**From:** Mark Berry <markberry@jsaarchitects.com>  
**Sent:** 26 February 2020 17:56  
**To:** Rebekah Morgan  
**Cc:** Veronique Bensadou  
**Subject:** RE: 16/00472/OUT - S Grundon Services Ltd, Merton Street, Banbury  
**Attachments:** A3810 - Grundon Waste Management, Banbury (O) 002.pdf

**From:** Trevor Dixon <[Trevor.Dixon@Cherwell-DC.gov.uk](mailto:Trevor.Dixon@Cherwell-DC.gov.uk)>  
**Sent:** 19 September 2019 12:42  
**To:** Rebekah Morgan <[rebekah.morgan@cherwell-dc.gov.uk](mailto:rebekah.morgan@cherwell-dc.gov.uk)>  
**Subject:** 16/00472/OUT - S Grundon Services Ltd, Merton Street, Banbury

Figure 2-Statistical distribution of night-time background sound levels (LMD noise excluded)

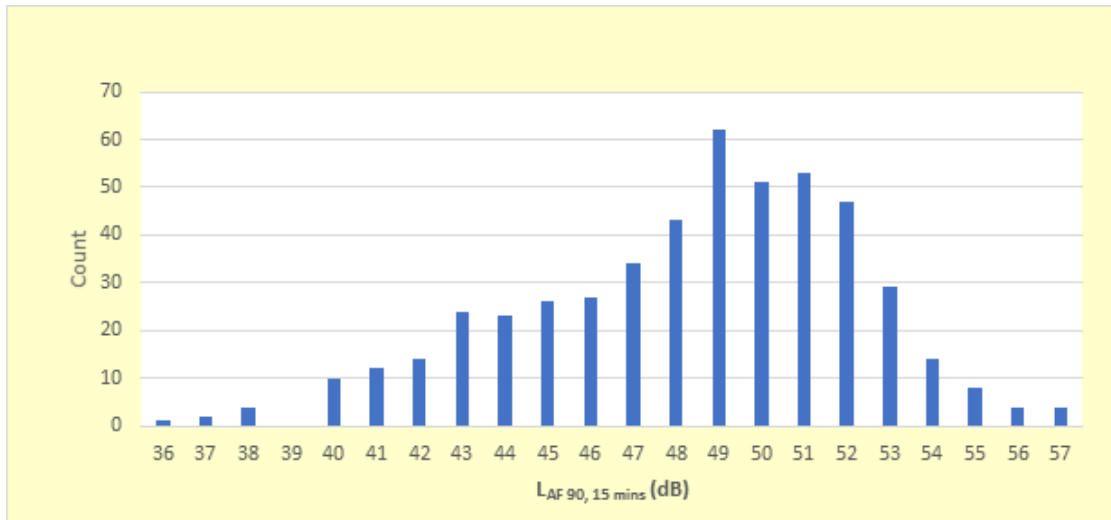
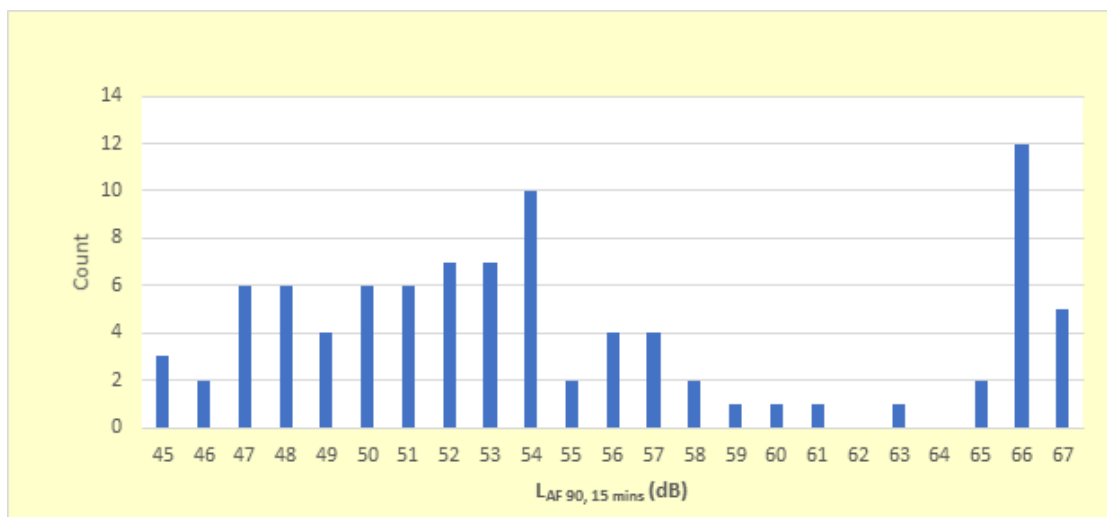
In answer to my previous questions on this AJA have confirmed they have taken the average for each day and night time monitoring period and referred to figures 8, 9, 10 and 11 in the report. What I was after was the range of levels measured during the night time periods in particular, to be clear that a representative level has been used and not just the average for the monitoring period.
